From: Dave Horrocks [REDACTED]
Sent: 26 March 2019 11:42
To: Tom Edmunds
Cc: 'Beanland, Ben'; 'JasonGarrod'
Subject: RE: Butlins Bognor Regis | confirmation of conclusions of noise report

The current application proposes to vary the conditions of the two decision notices which comprise the consented scheme – BR/240/16/PL Jan 2017 (original consent) and BR/331/17/PL March 2018 (changes to the construction phasing) – switching out some of the approved drawings with new, proposed drawings.

As discussed, we need to provide the Council with written confirmation that the minor design changes proposed by this current application (ref. BR/39/19/PL) will not affect the conclusions of the approved acoustic report. I attach this for ease of reference.

job: 5128 dwg: P201 rev: D

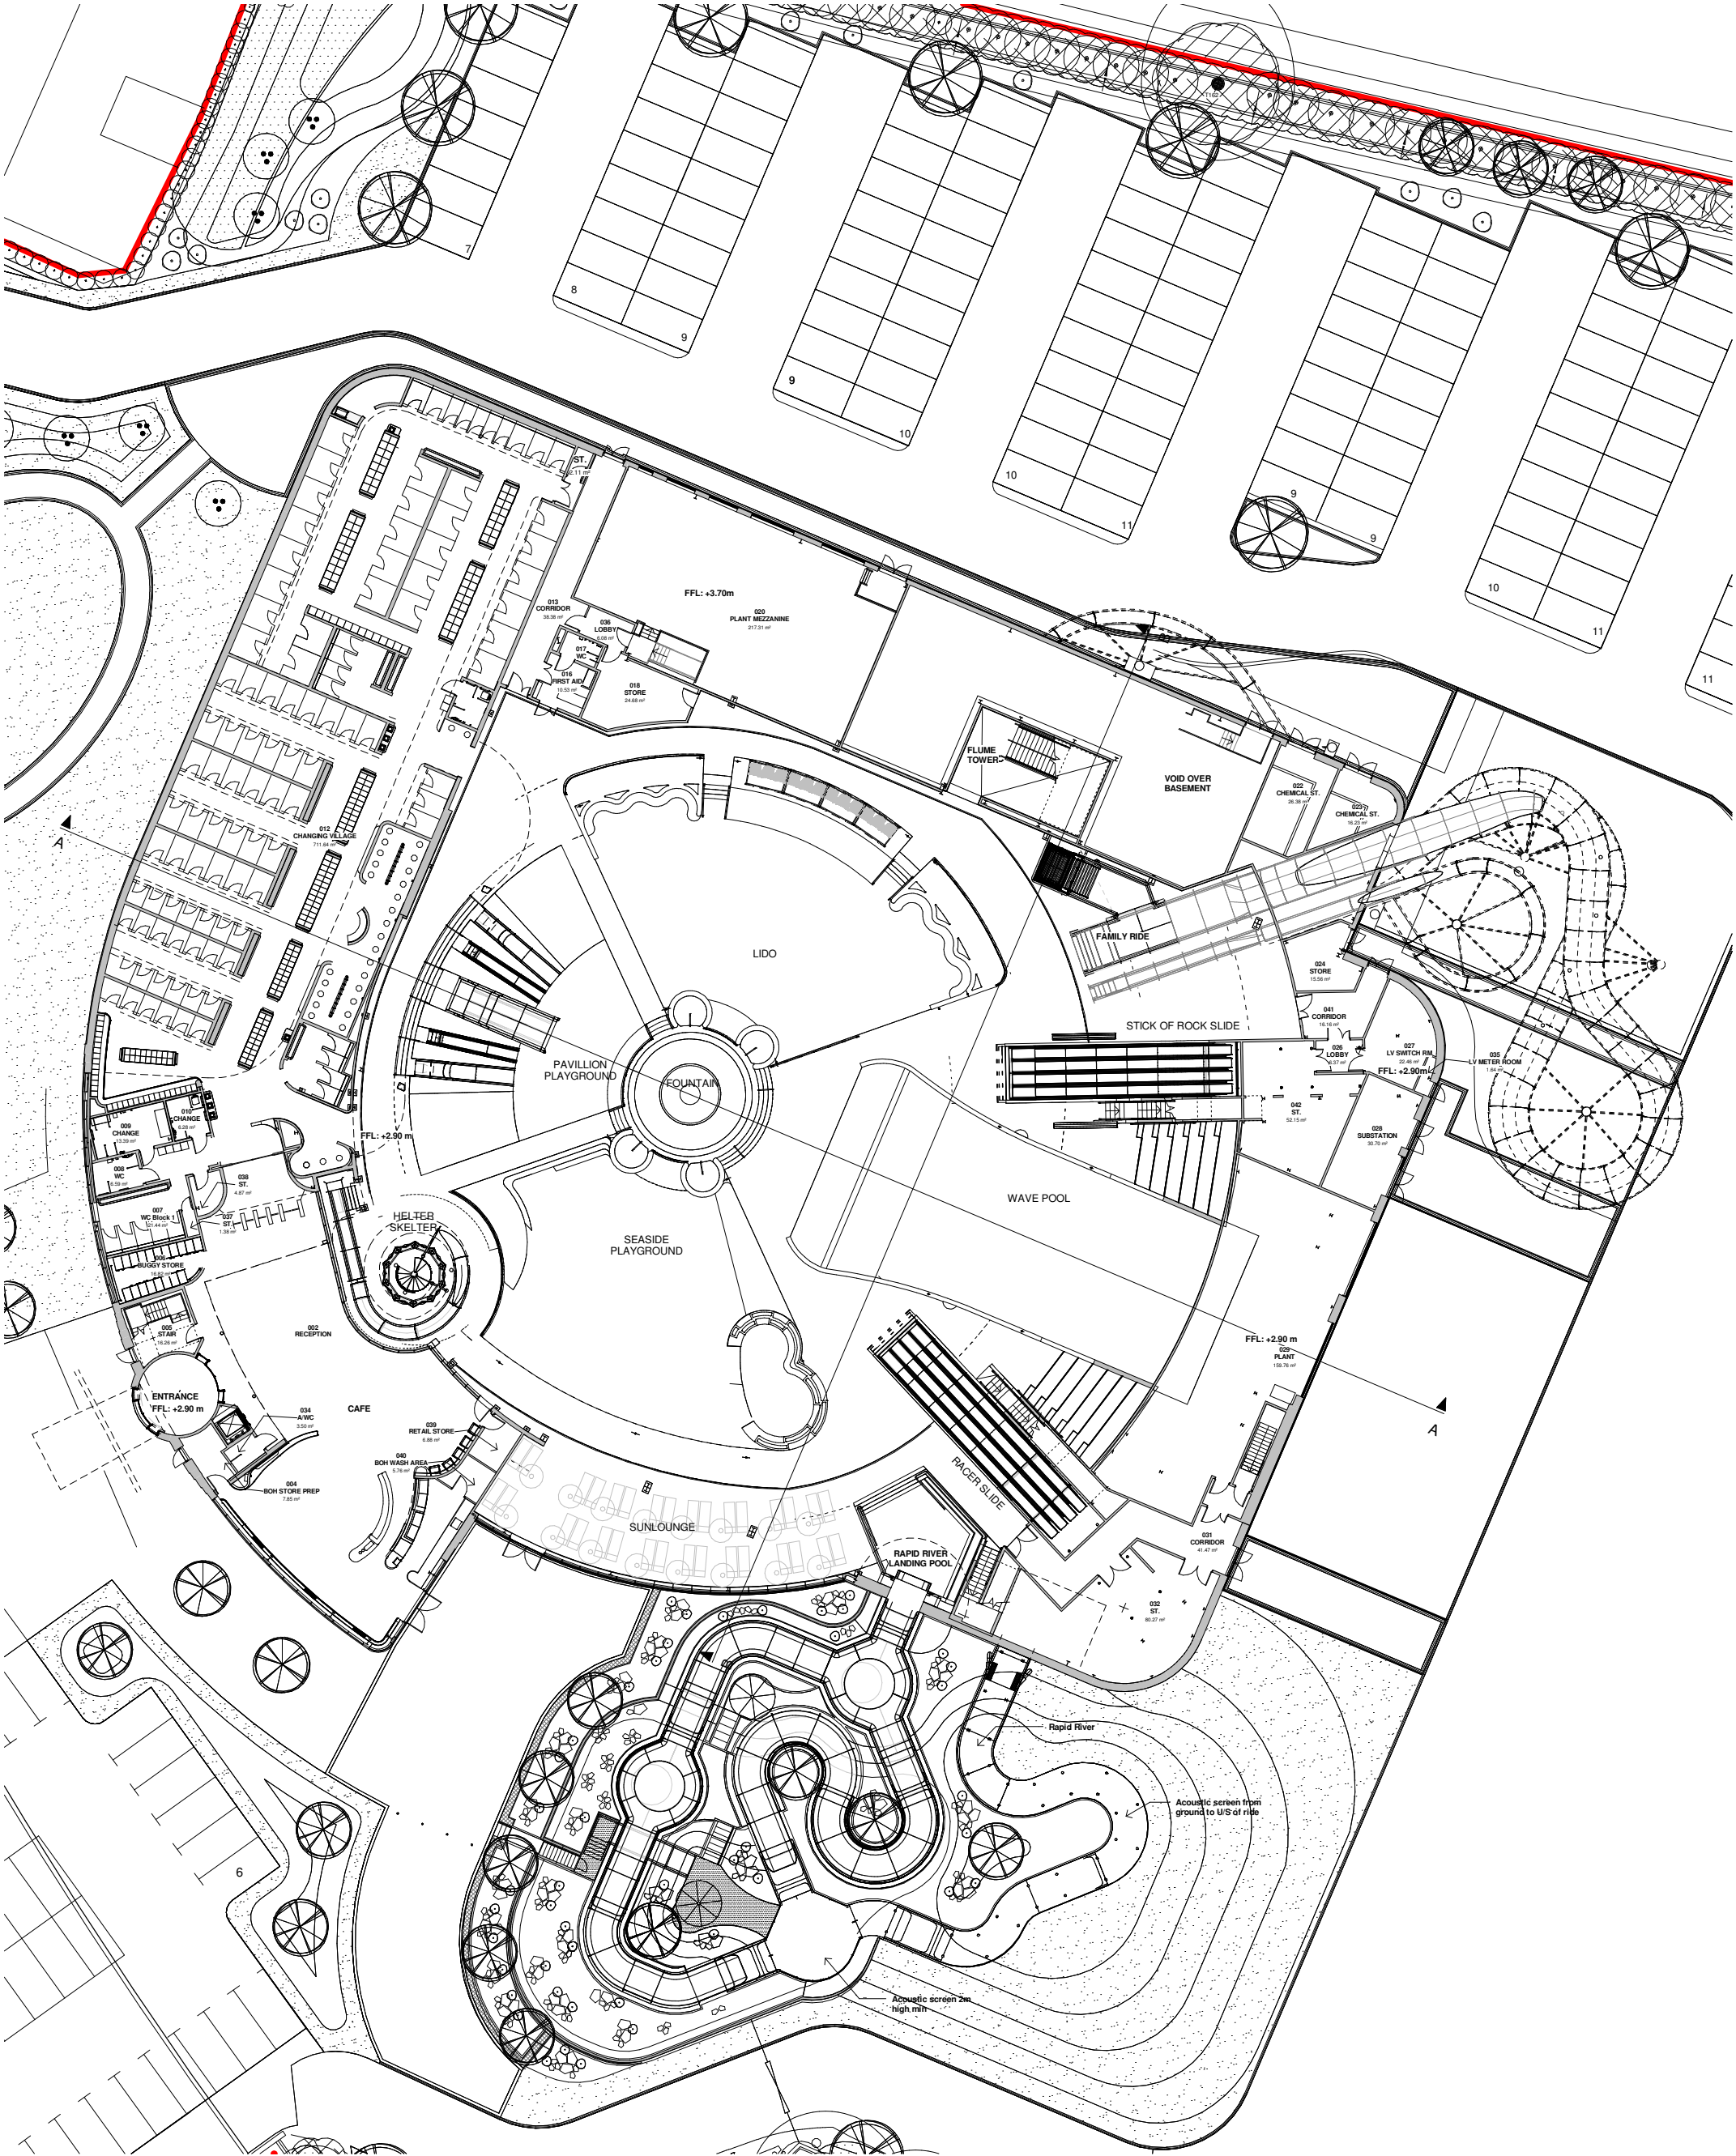
Specifically, the Council's environmental health officer has requested confirmation that the change to the rapid river ride and change to the flume tower will have no adverse impact on the acoustic environment. The Council have already confirmed that if this is the case then environmental health would have no objection to the amendments.

I would expect this to be the case given the layout is essentially the same, in the same location, and employs the same acoustic mitigation as per your report – namely acoustic screens and the first section of the ride being in an enclosed 'tube' – however please can you confirm in writing by reply to this email so that I can feed that back to the Council.

I attach your noise report, approved drawings P201C & P301D, and proposed drawings P201D & P301E.

I have studied the new proposed drawings and I can confirm that these minor design changes do not change the conclusions of my revised and updated acoustic report dated 11th November 2016 since the proposed acoustic mitigation works will remain the same, ie the incorporation of acoustic screens and with the first section of the ride being in an enclosed 'tube.'
